Item No. **Report of the Head of Planning, Transportation and Regeneration**

Address 105 FIELD END ROAD EASTCOTE PINNER

Development: Installation of rooftop plant equipment to serve ground floor restaurant unit (Retrospective)

LBH Ref Nos: **21404/APP/2020/3281**

Project Address: 105 Field End Road, Eastcote	
Project Name: Eastcote Karahi rear shed	
SHEET NAME: Existing and Proposed Block Plans

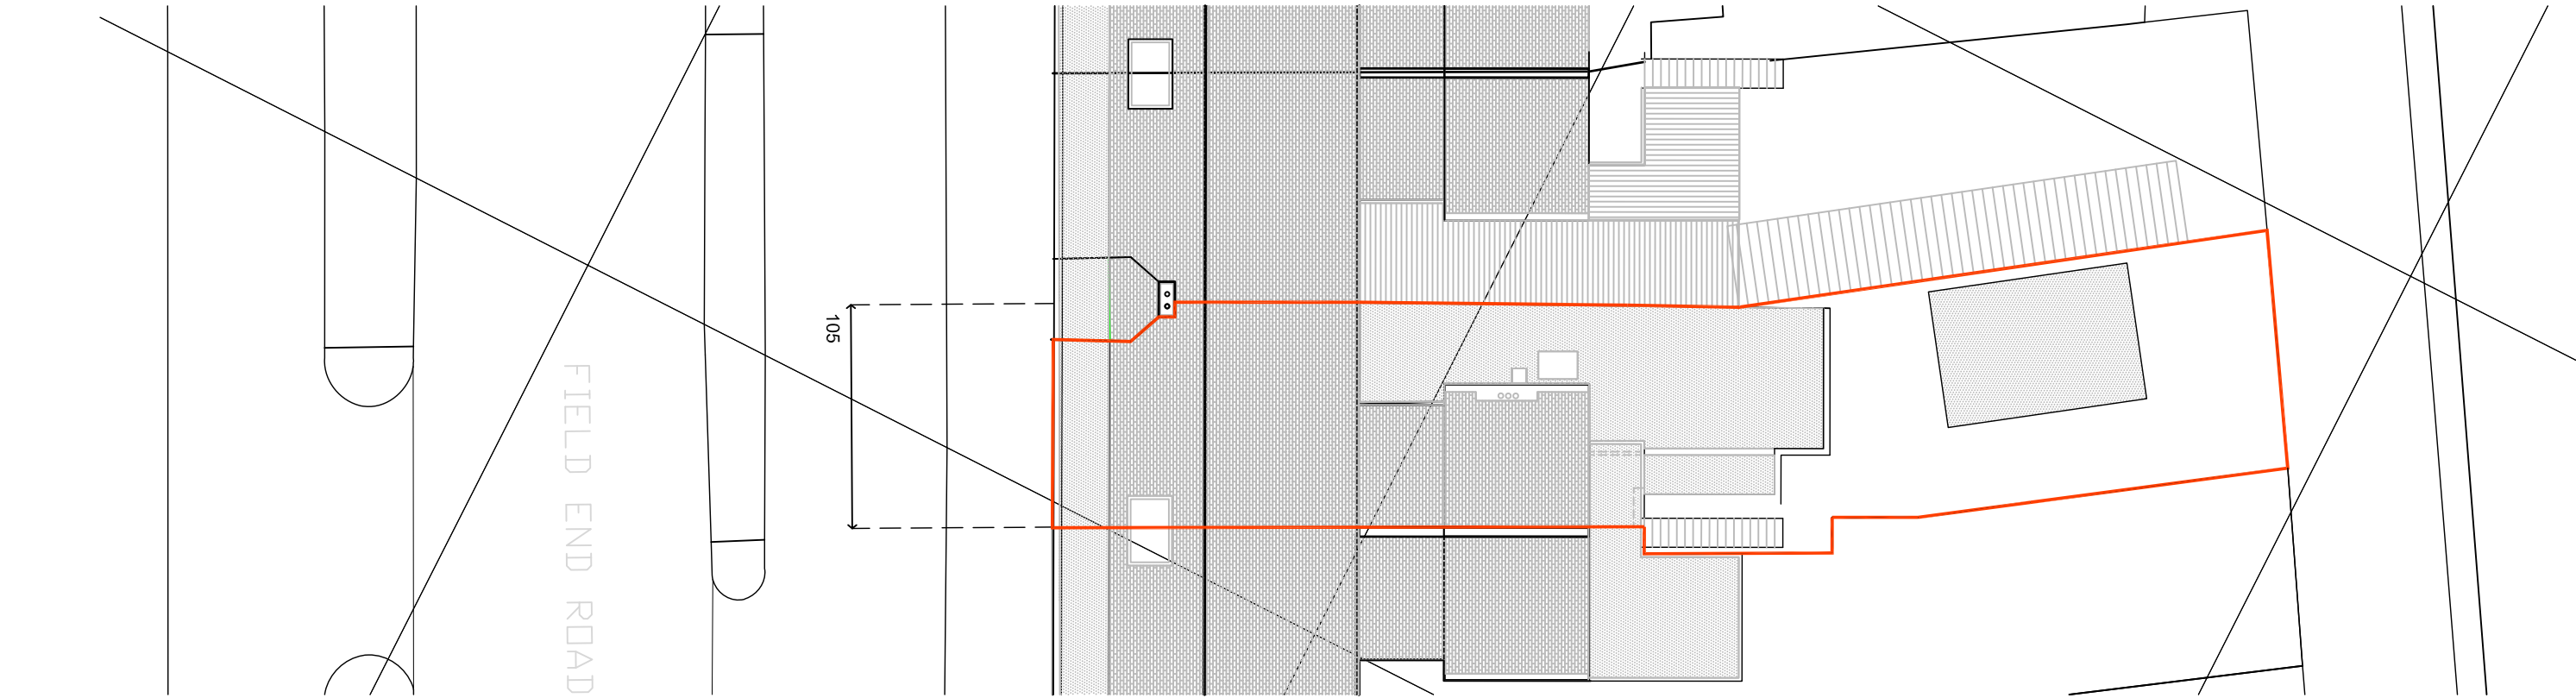
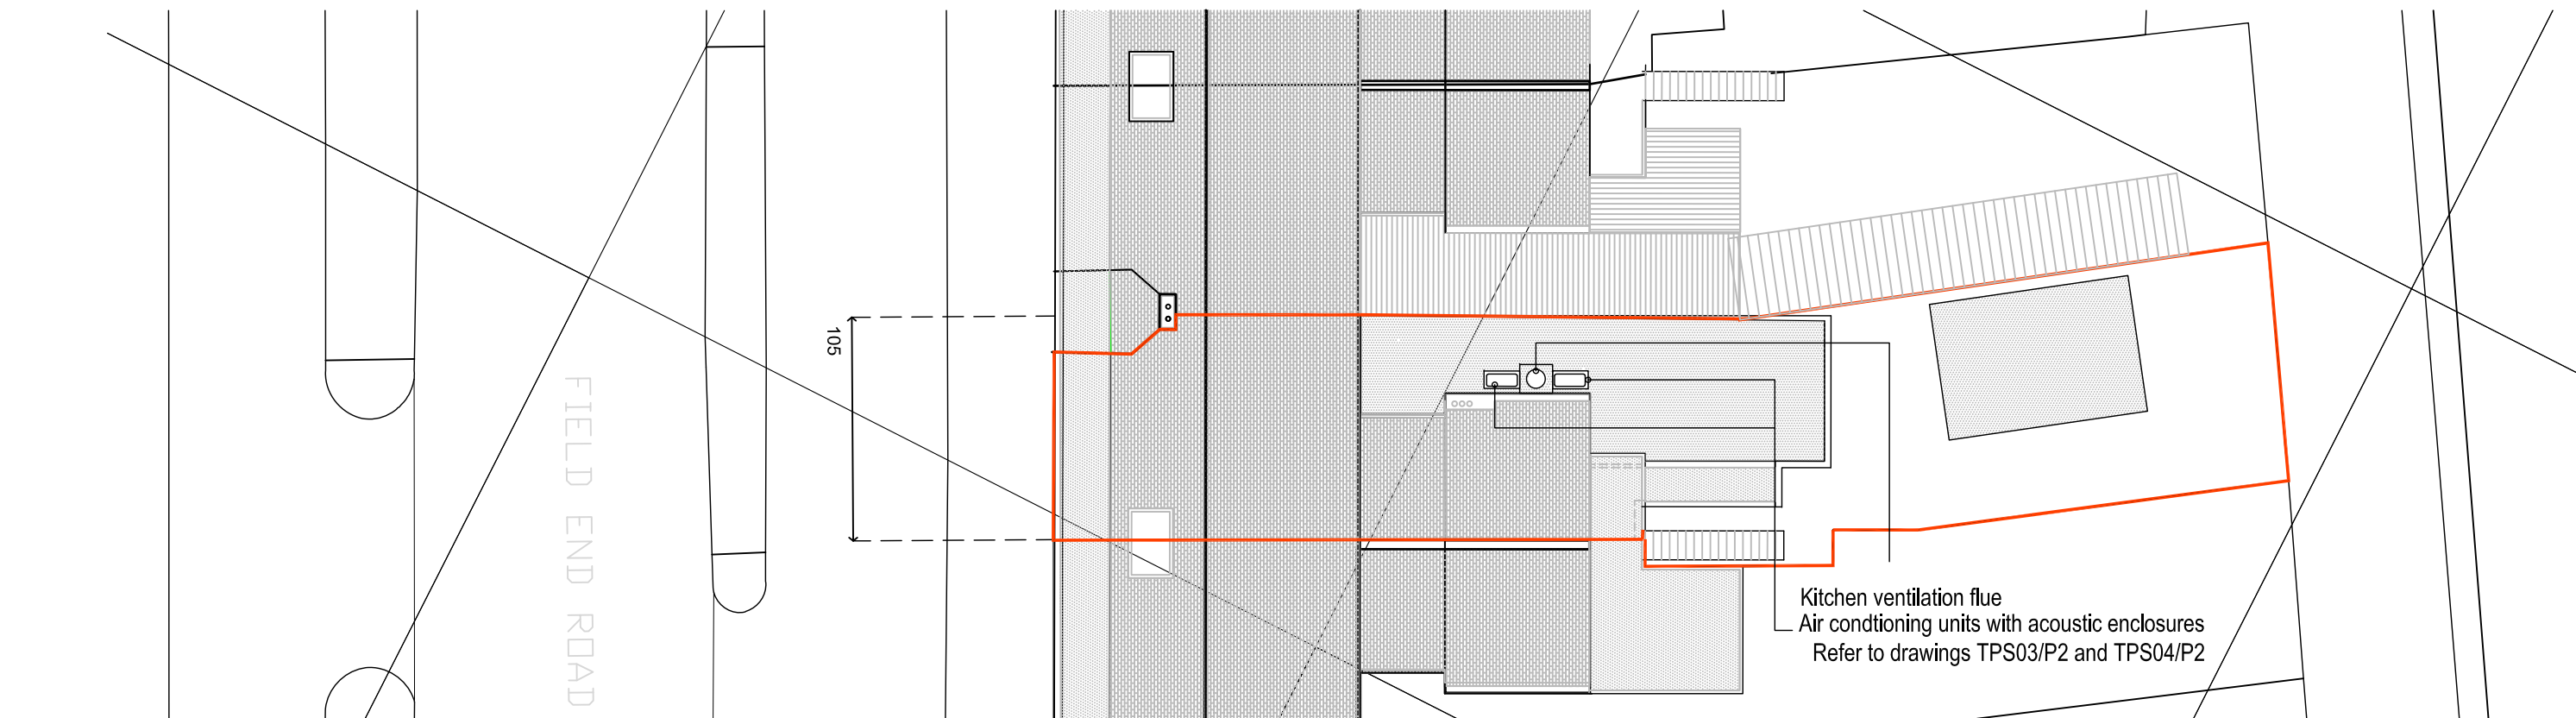
It has not been demonstrated that the design of the rooftop plant equipment to serve the ground floor restaurant unit satisfactorily mitigates noise and odour emissions and that it is not harmful to the residential amenities of neighbours As such the development is contrary to Policies DMTC 4 and DMHB 11 of the Hillingdon Local Plan: Part Two - Development Management Policies (January 2020), Policy 7.15 of the London Plan (2016) and the National Planning Policy Framework.

The plant equipment, by reason of its siting including its location in front of a first floor residential window, size, scale and design results in an incongruous design feature, which is detrimental to the amenities of adjoining residential occupiers and the wider area, by reason of loss of outlook. As such the development is contrary to Policies DMTC 4 and DMHB 11 of the Hillingdon Local Plan: Part Two - Development Management Policies (January 2020).

Council's experts as shown in the 'Consultation' section above. This concludes that It is not clear where the mitigation in the noise and odour assessment (Nov 2020) has been reflected in the plans (Oct 2020) that are being put forward for approval. The solution appears to be incongruous and it is not clear whether it reflects the mitigation that would solve the original problems. From a design perspective, the solution to one problem appears to create another.

The equipment is located to the rear of the property and does not have any impact on Field End Road. However, it does extend beyond the ground floor and is located in front of a first floor window. This results in a significant and harmful visual intrusion to the adjoining properties and the wider area.
